# HERTFORDSHIRE ECOLOGY

**Application ID: S6/2015/1061/MA**

**Location: Plot 6000, Hatfield Business Park, Hatfield**

**Description: Erection of a private healthcare facility (use Class C2), to include car/cycle parking, boundary treatment, landscaping, lighting and access.**

drawing title:
 Phase 2 Proposed Site Plan
 and Landscaping Proposals

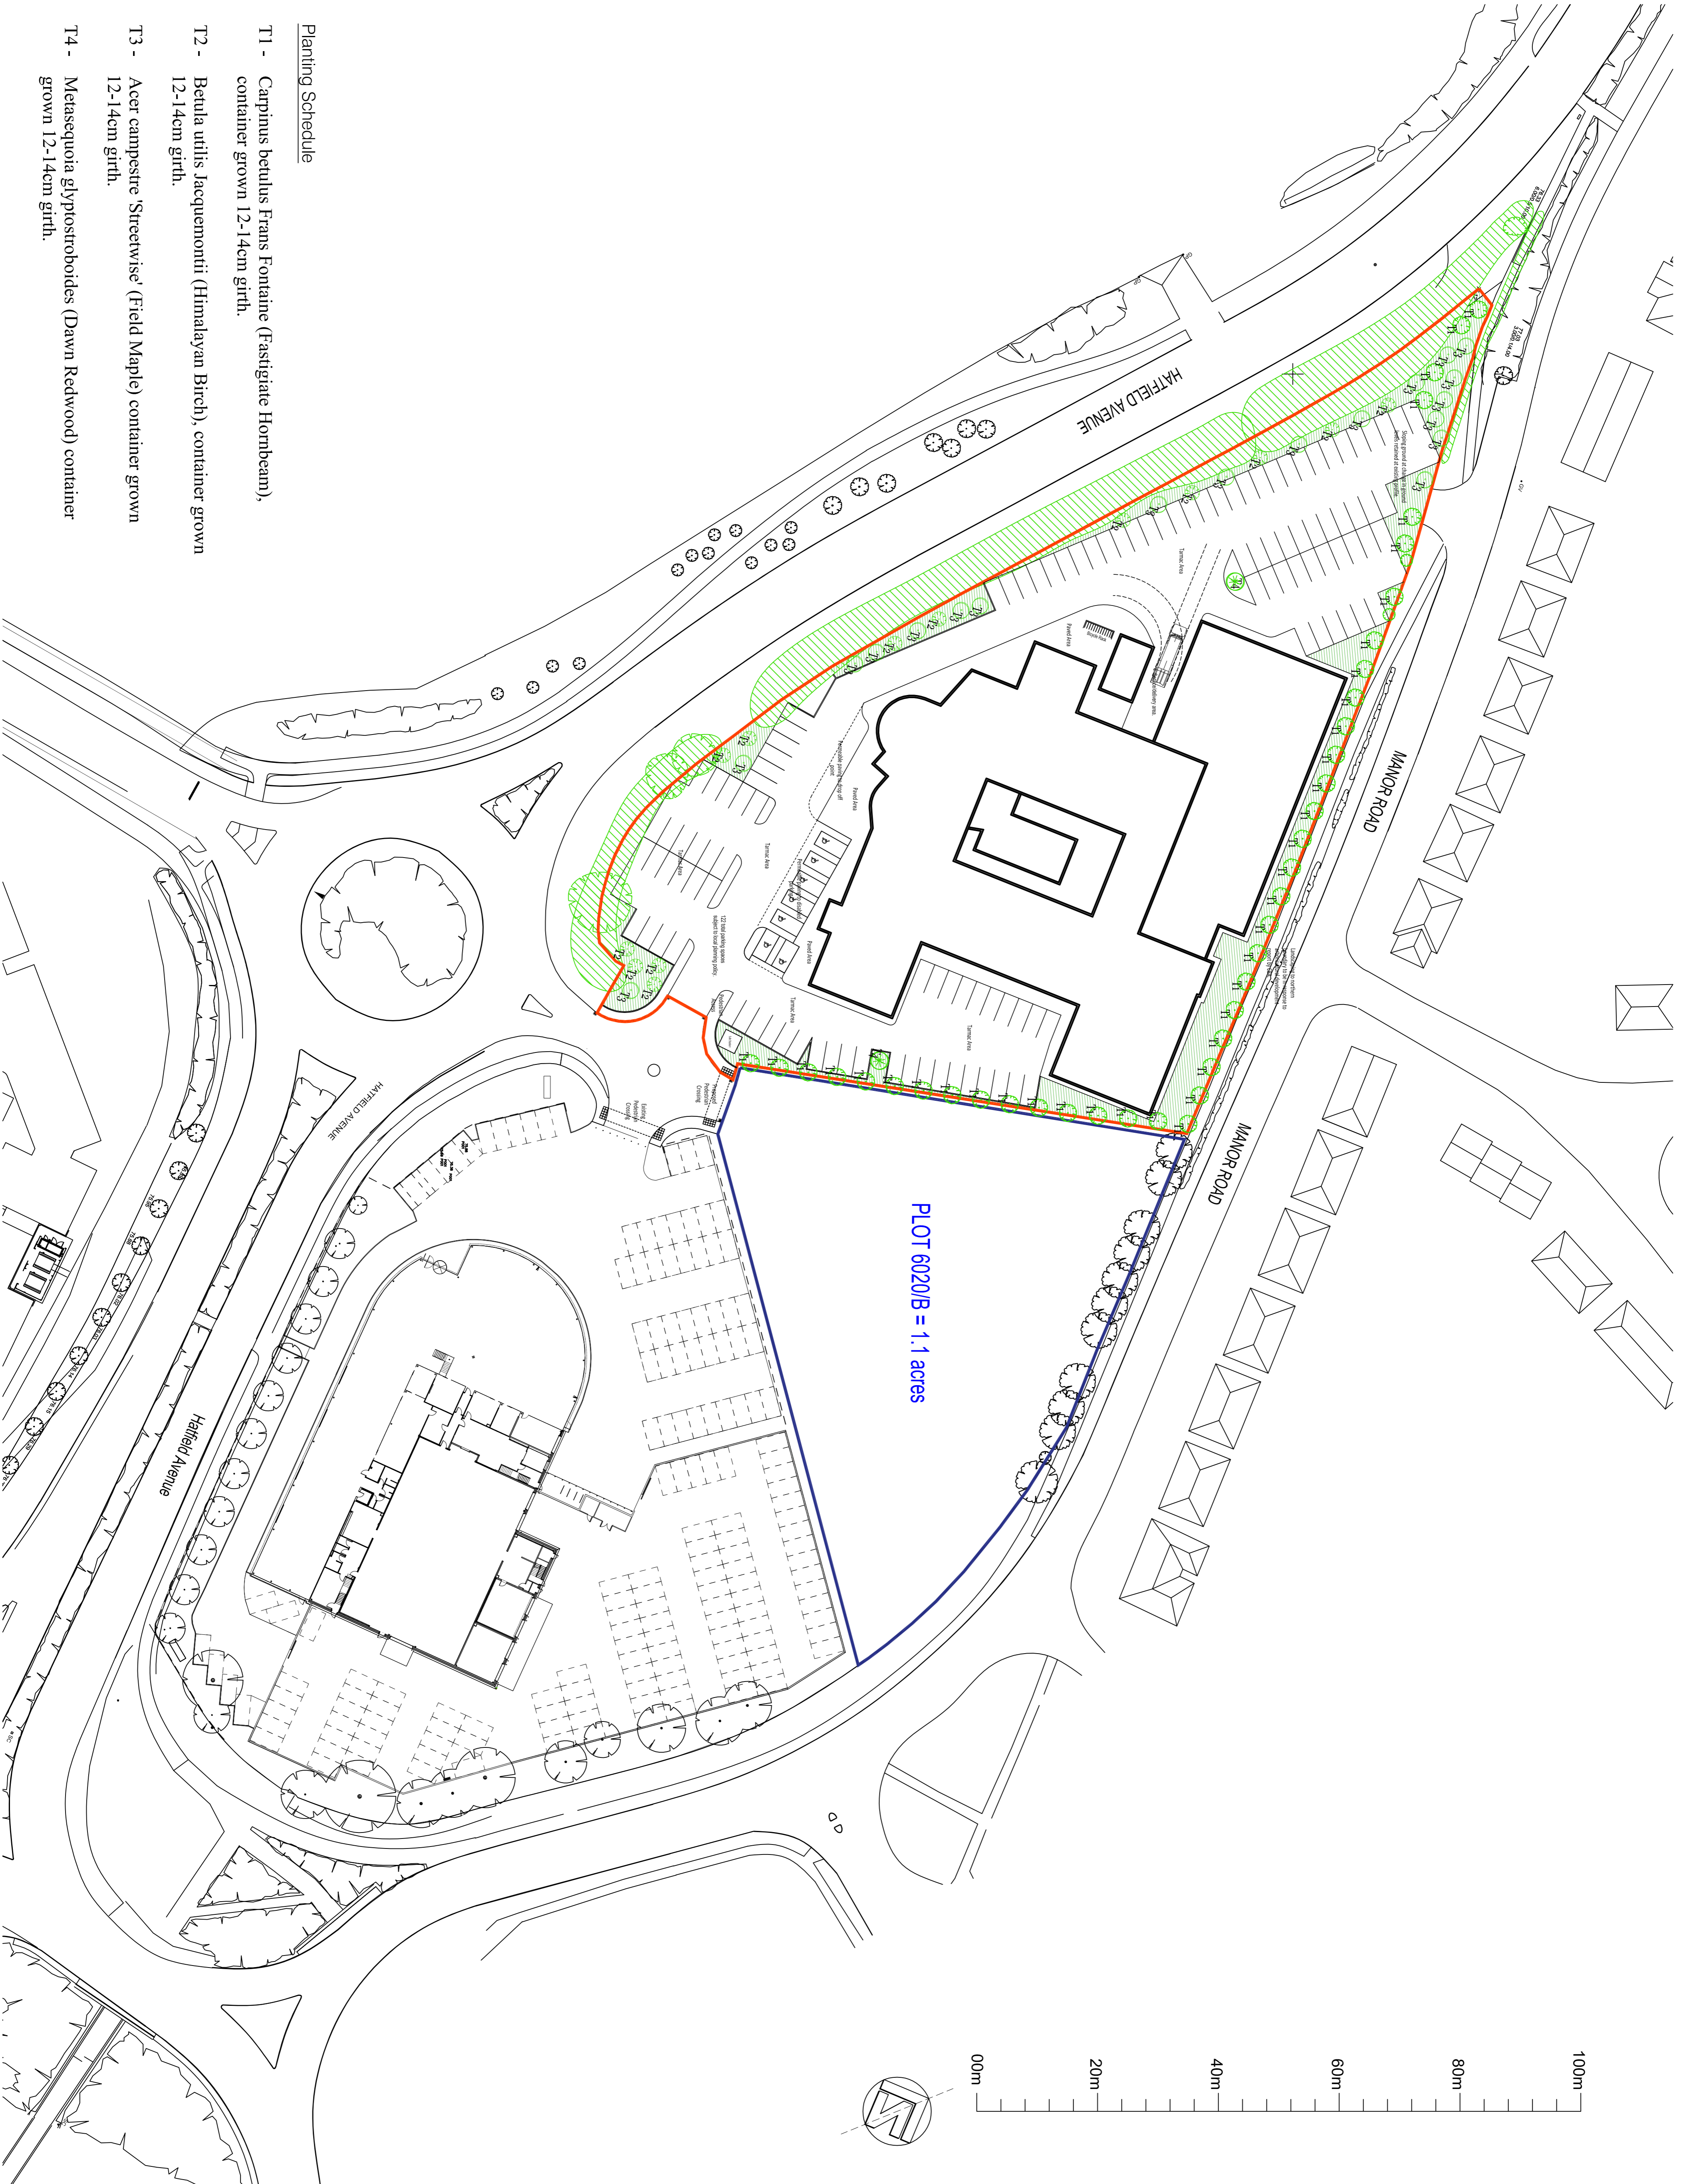
2. ***“Any external lighting scheme should be designed to minimise light spill, in particular directing light away from the boundary vegetation to ensure dark corridors remain for use by wildlife as well as directing lighting away from potential roost / nesting site.”***

3. ***Soft landscaping – “new trees and shrubs should be predominantly native species, particularly those that bear blossom and fruit (berries) to support local wildlife. Where non-native species are used they should be beneficial to biodiversity, providing a food source or habitat for wildlife.”***

No Biodiversity enhancements have been suggested which goes against the requirement of the NPPF for new developments to achieve a net gain for biodiversity; and to contribute to the green infrastructure network. Biodiversity enhancements should be incorporated into the development proposals, submitted and approved by the LPA, and secured by **Condition of Approval:**

4. ***“Biodiversity enhancements should be considered and could be in form of bat and bird boxes in trees, integrated bat roost units (bricks and tubes) in buildings, refuge habitats (e.g. log piles, hibernacula) for reptiles at the site boundaries, green roofs, wildflower / wetland / pond areas, etc. These should be considered at an early stage to avoid potential conflict with any external lighting plans. Advice on type and location of habitat structures should be sought from an ecologist.”***
